Application by Roxhill (Junction 15) Limited for a Development Consent Order for the Northampton Gateway Rail Freight Interchange

The Examining Authority's written questions and requests for information (ExQ2)

Issued on 5 February 2019

**Figure 9.14: Local Operational Impacts - Blisworth & Milton Malsor**  
 Contains Ordnance Survey data © Crown copyright and database right 2017

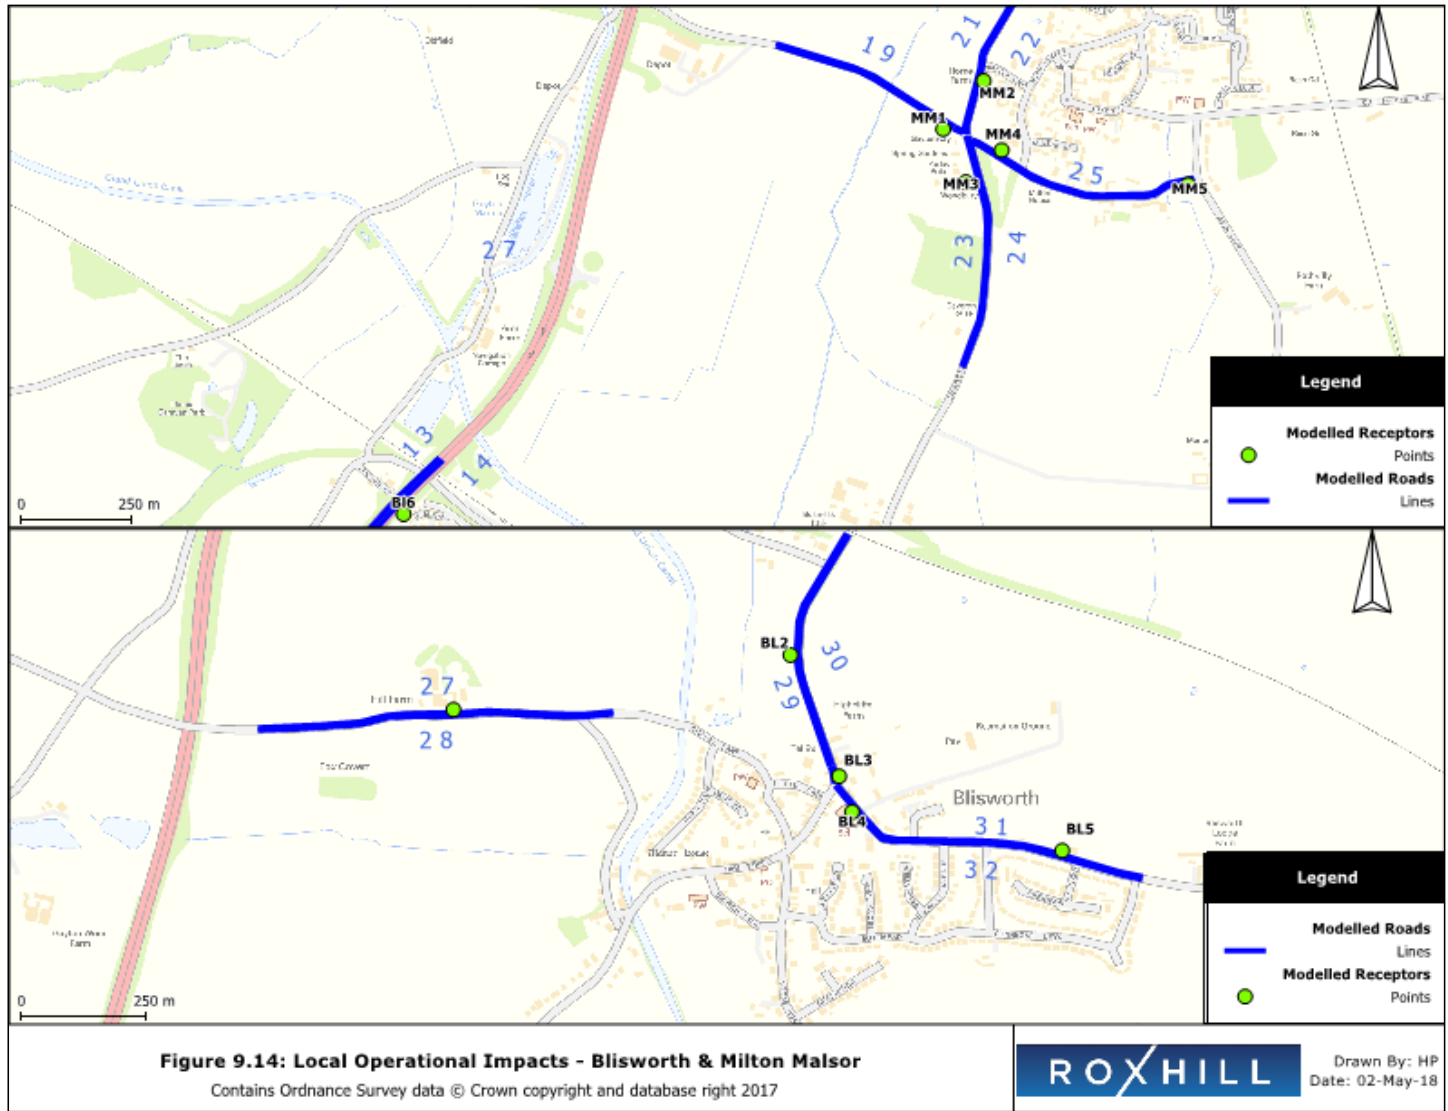
2.1.15.		<p>Para 9.5.133. There is no modelled receptor labelled BL1 on Figure 9.14. Is it the unlabelled receptor on Gayton Road?</p>
2.1.16.		<p>Para 9.5.158 and Tables 9.33 and 9.34. There are no 2018 baseline data for any of the modelled locations in the Grafton Regis and Pottersbury Study Area. Please will the Applicant explain why and indicate how the predicted no development figures in columns B of those two tables can be relied on?</p>

Figure 9.1: Northampton Gateway Construction Phase Receptors

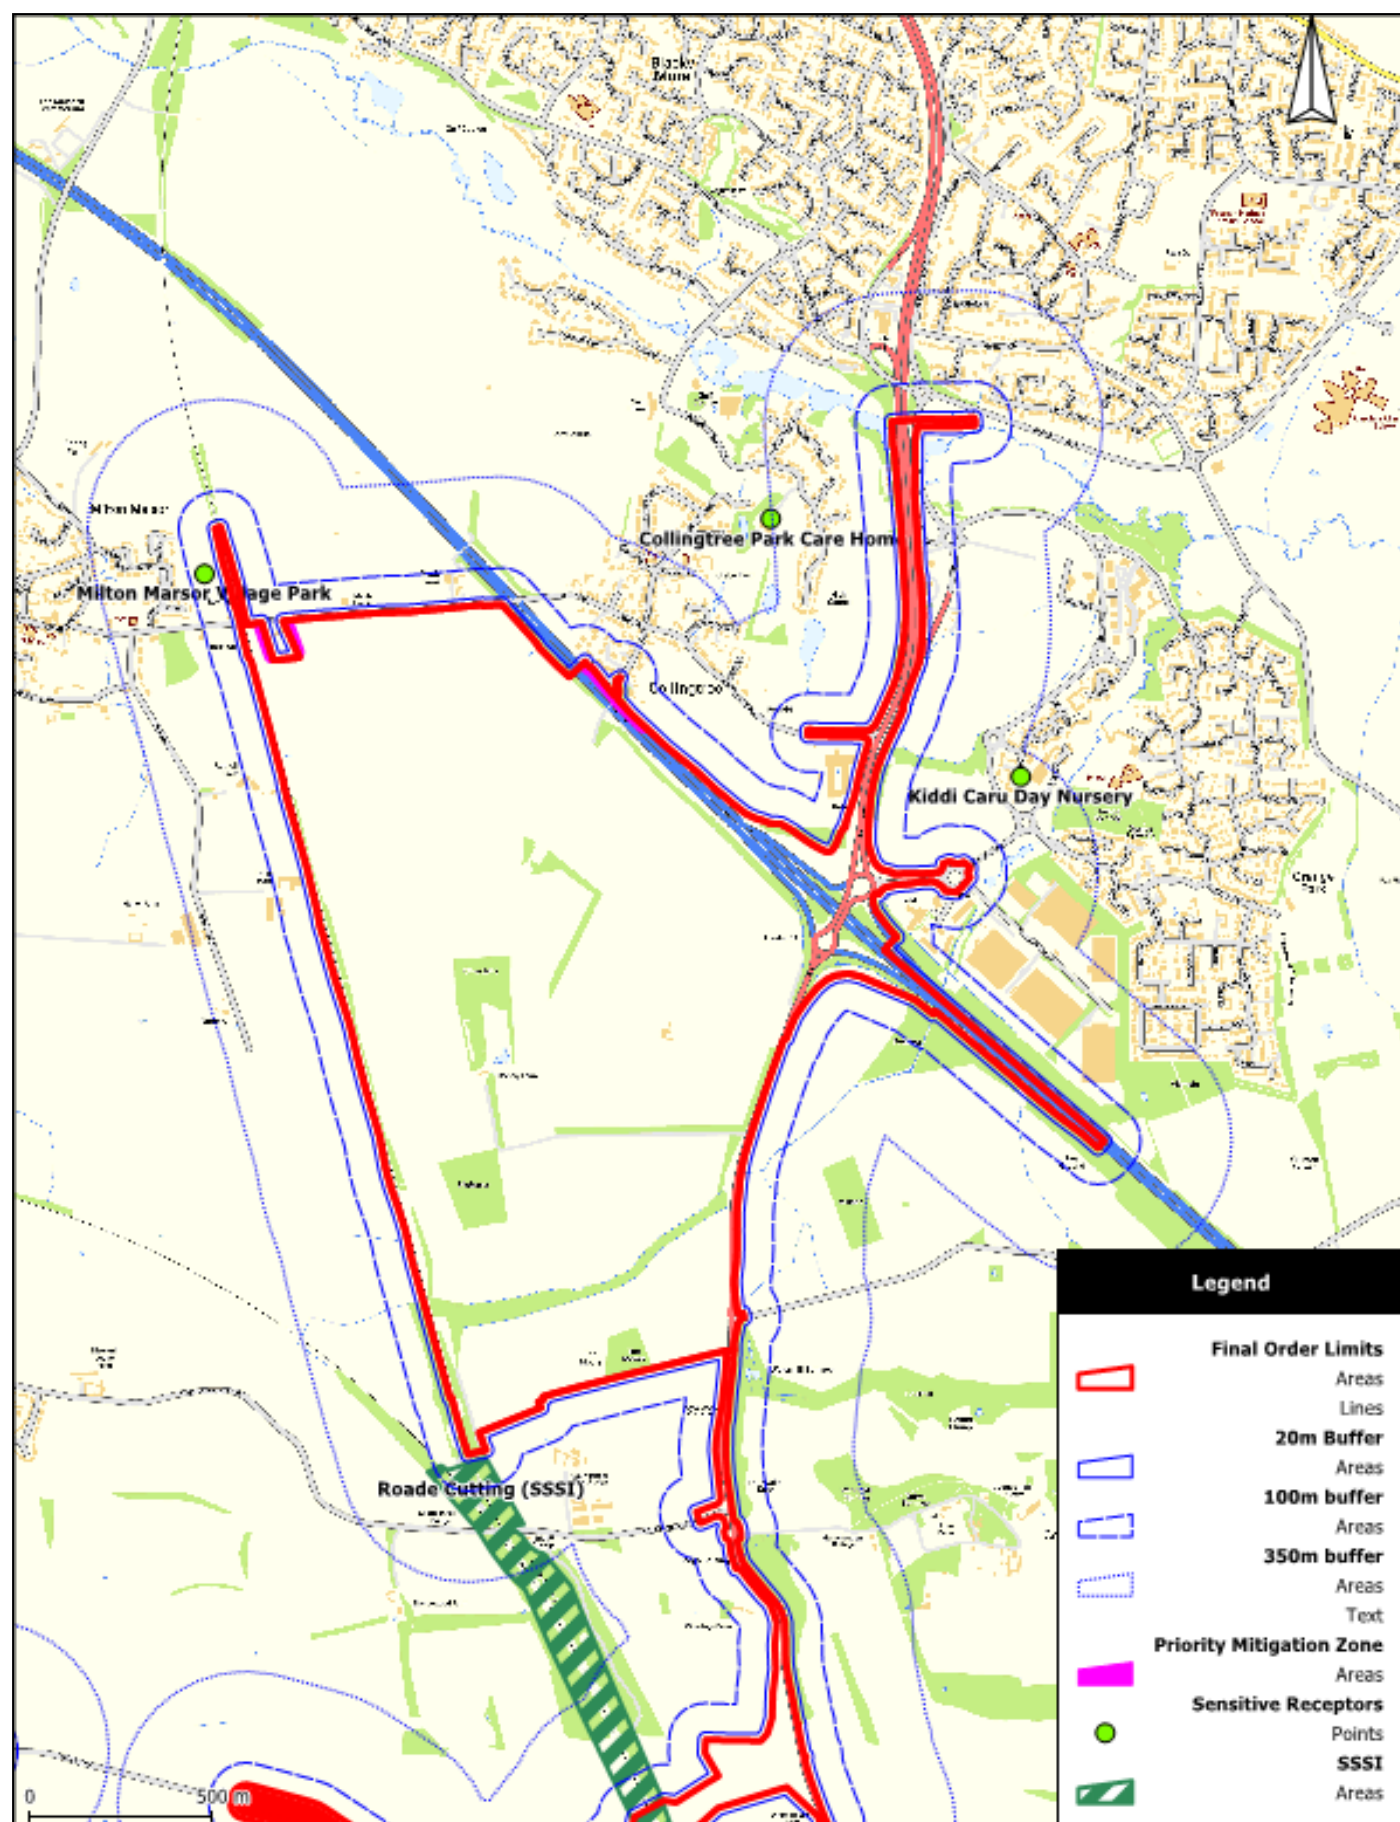
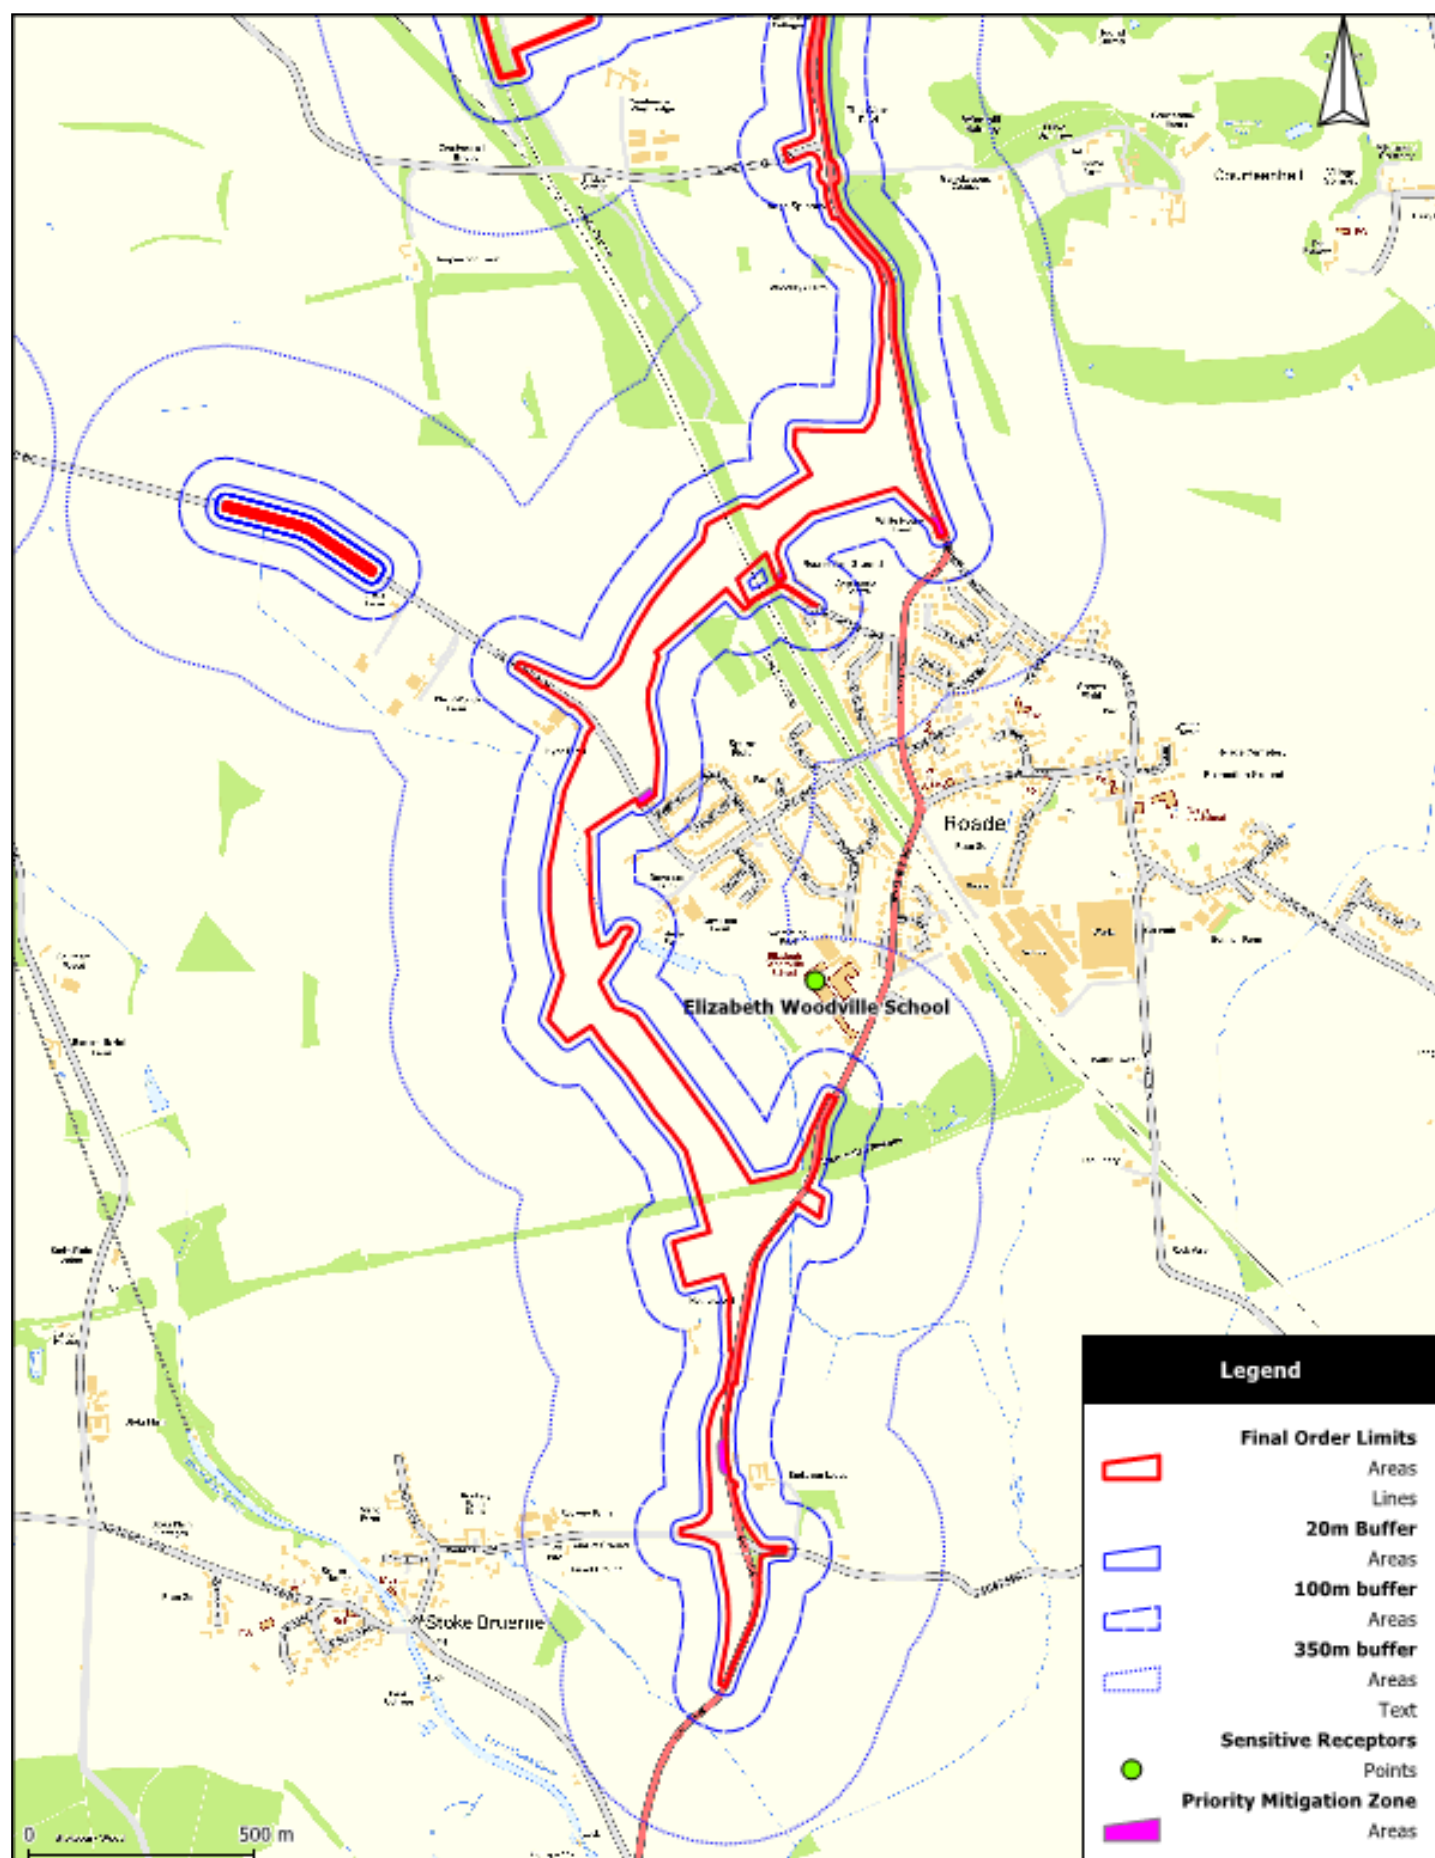
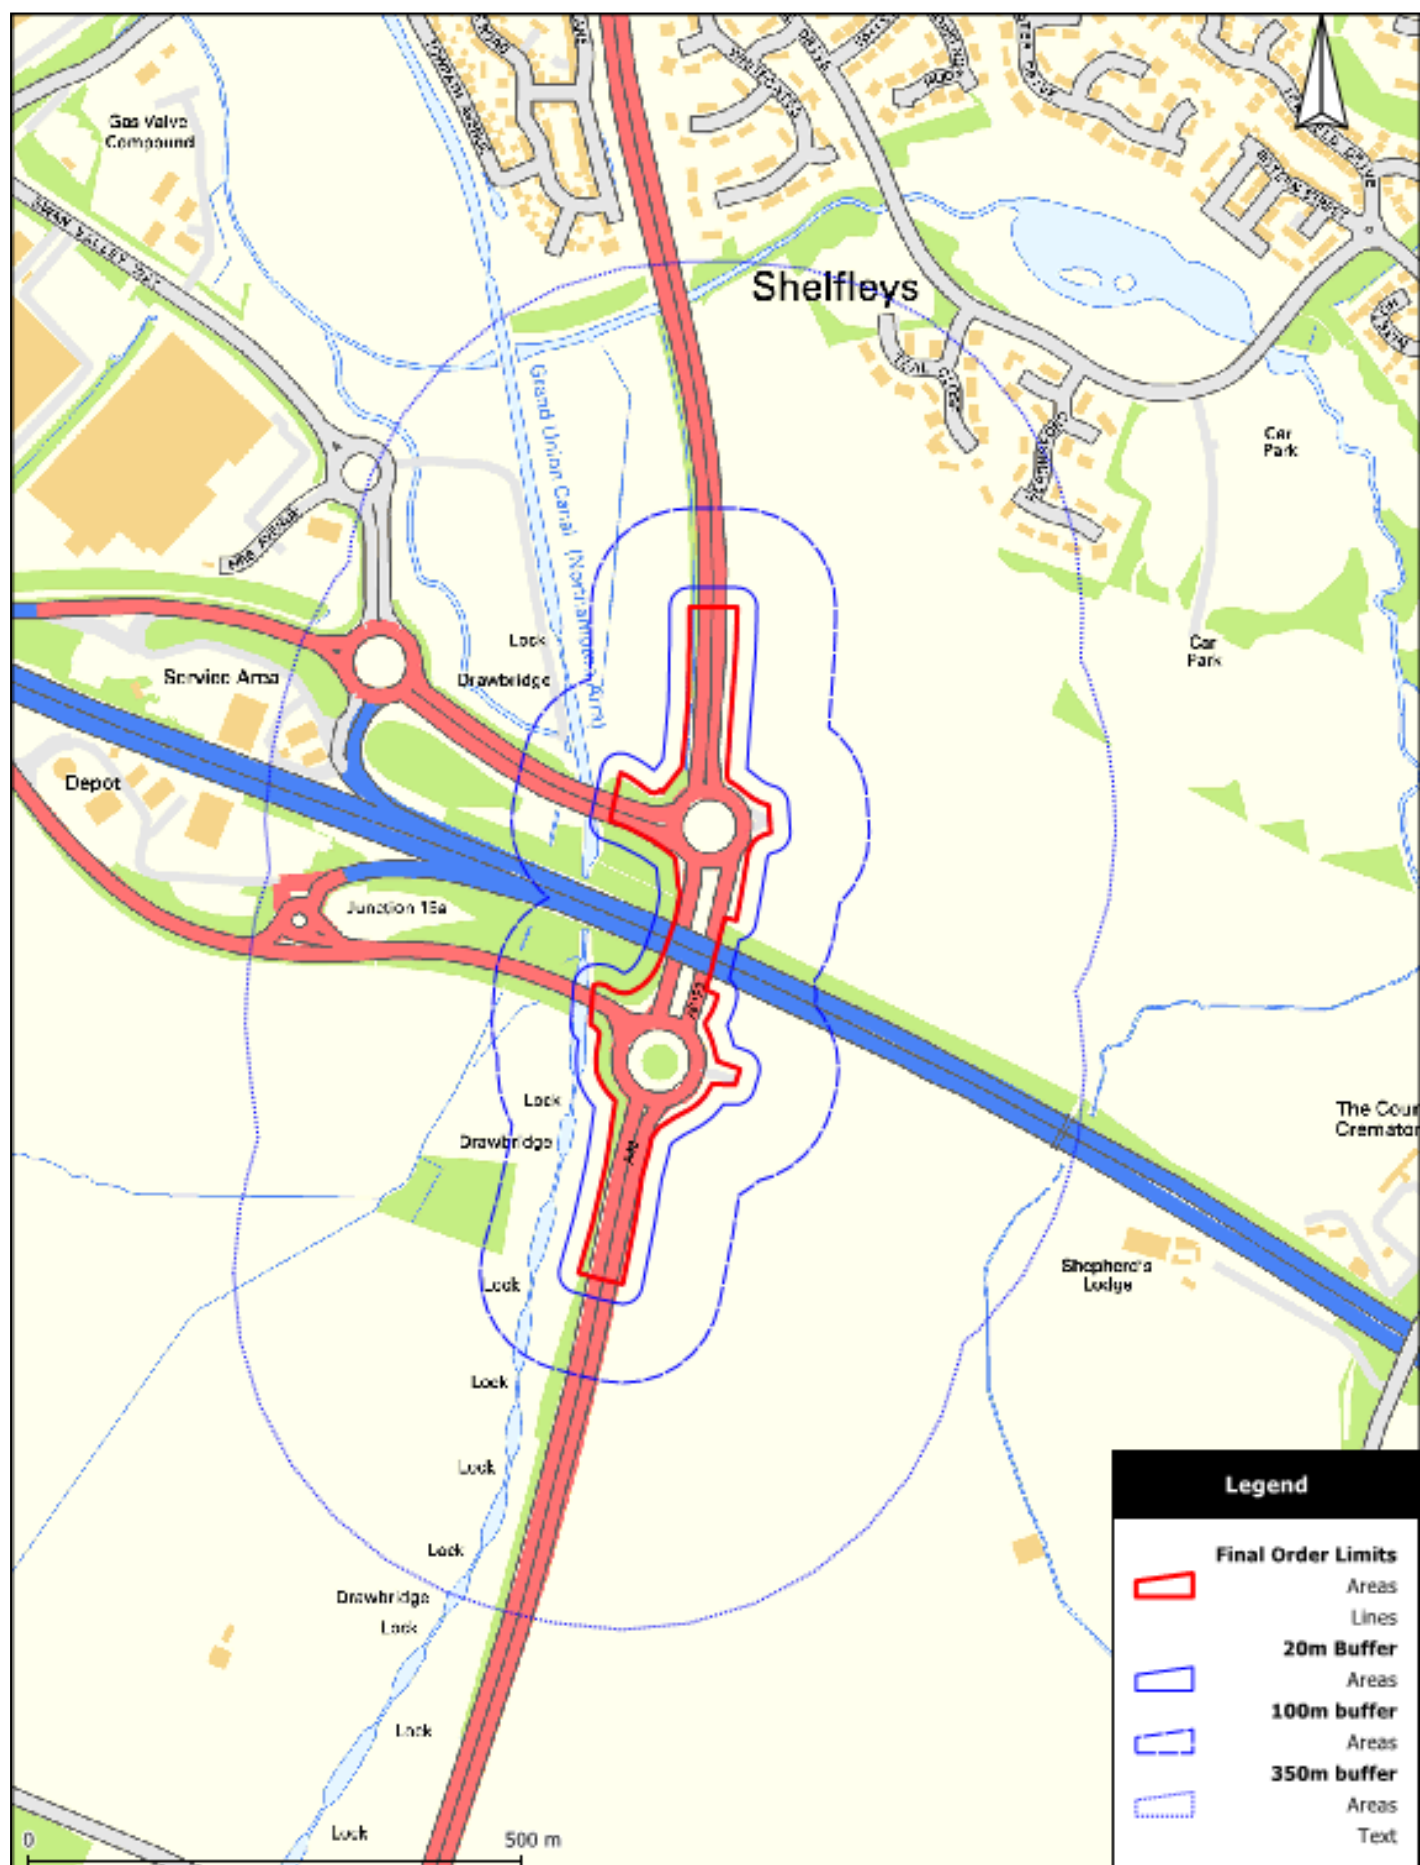
2.1.19.		<p>Para 9.6.3 on Dust Mitigation says "The highest risk activities will be avoided in the areas of the Main Site closest to sensitive receptors. These are shown as a Priority Dust Mitigation Zone on Figures 9.1, 9.2, 9.3 and 9.4. However, there do not appear to be any such zones on those Figures and they are referred to only in the Legend of Figs 9.1 and 9.2. Please will the Applicant explain where they are described in the text so that the ExA can understand where they are and provide updated figures to show these</p>

ExQ2	Question to:	Question:
		<p>zones?</p> <p>Please can the Applicant also explain how this mitigation is secured? The Priority Dust Mitigation Zones do not appear to be mentioned in the Commitments Tracker (Doc 6.11A [REP3-003]).</p>
